MECKLENBURG COUNTY
Park and Recreation Department

MEMORANDUM

DATE: November 29, 2021

RE: Rezoning Petition #2021-033 Charlotte Pipe and Foundry Company Rezoning

**RZ-1.0**

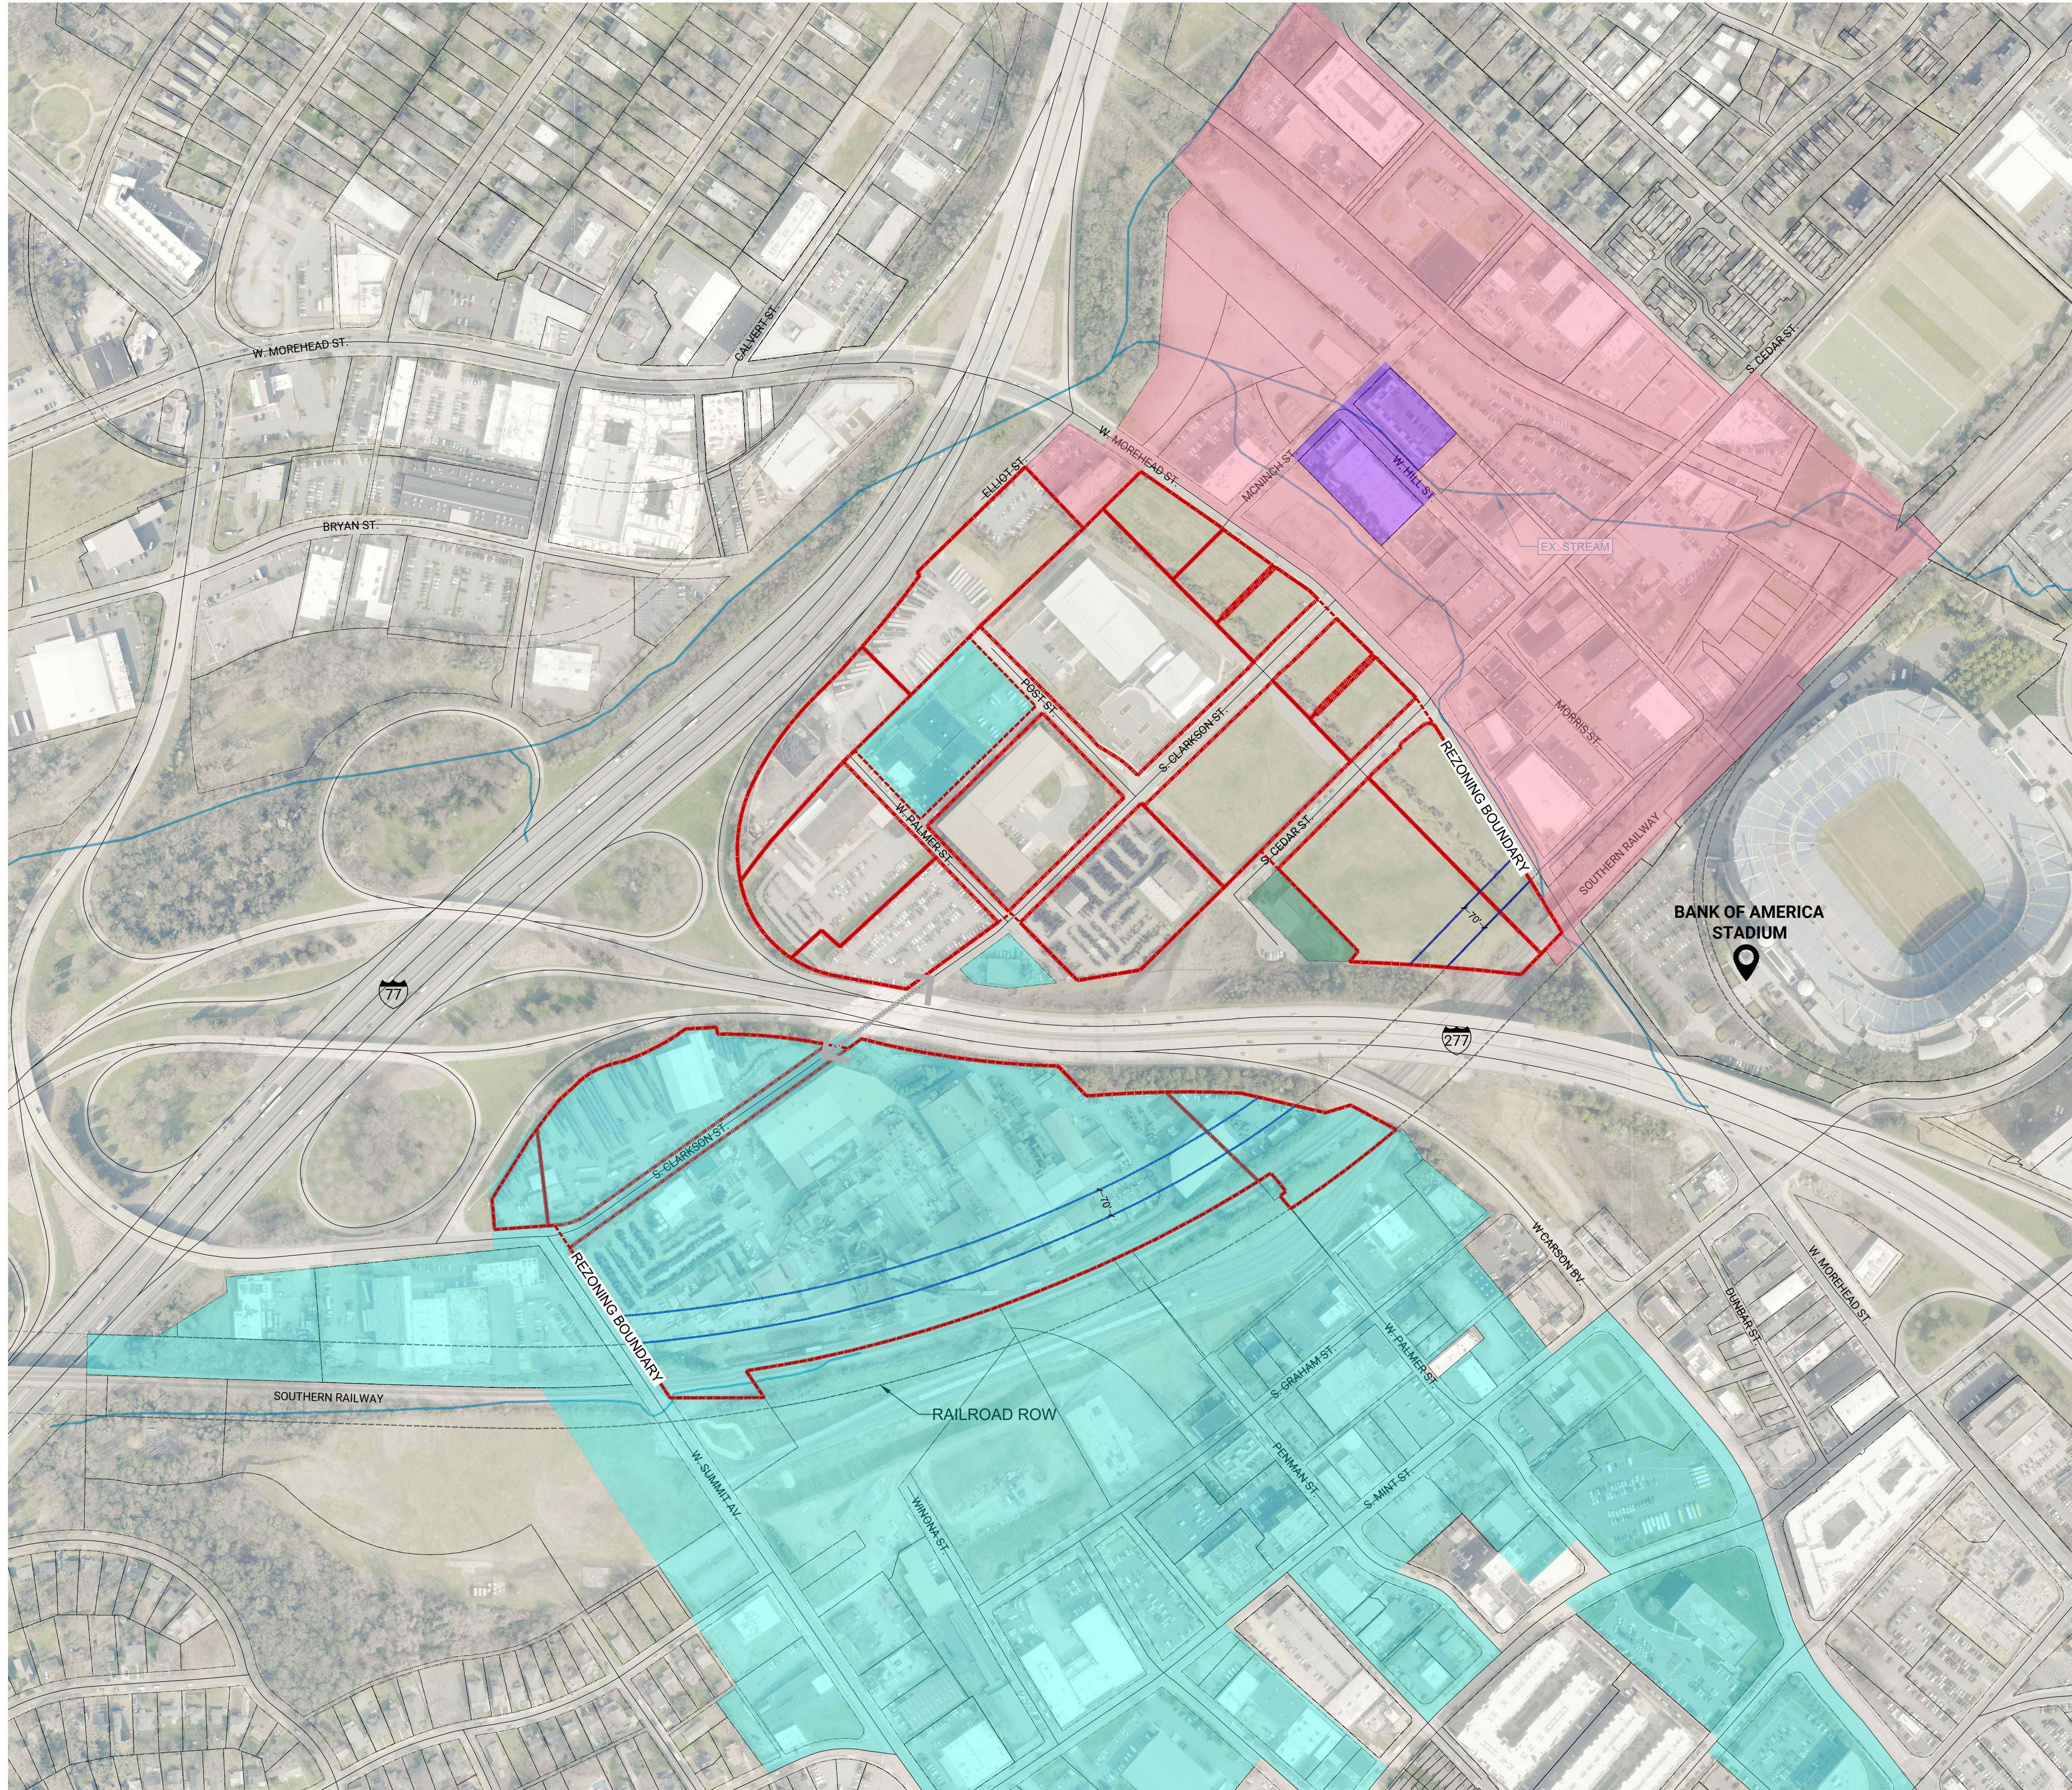
Previous comments (October 2021): MCPR requests a minimum of 2 acres to be dedicated and conveyed to Mecklenburg County for a future neighborhood park. This requested park land shall be adjacent to a public right-of-way for access and is conducive for the development of the typical amenities found in a neighborhood park and can not include tree save parcels. Contact MCPR with any questions/comments.

Updated comments (November 2021): MCPR is open to the petitioner utilizing the development's required open space to meet the needs of public park and recreation uses on the site. As discussed on a call with the development team on 11/12/21, MCPR requests that the petitioner adds a note to the plans regarding future coordination to ensure that open space is publicly accessible and consolidated into one or two areas as the development occurs. Contact MCPR with any questions/comments.
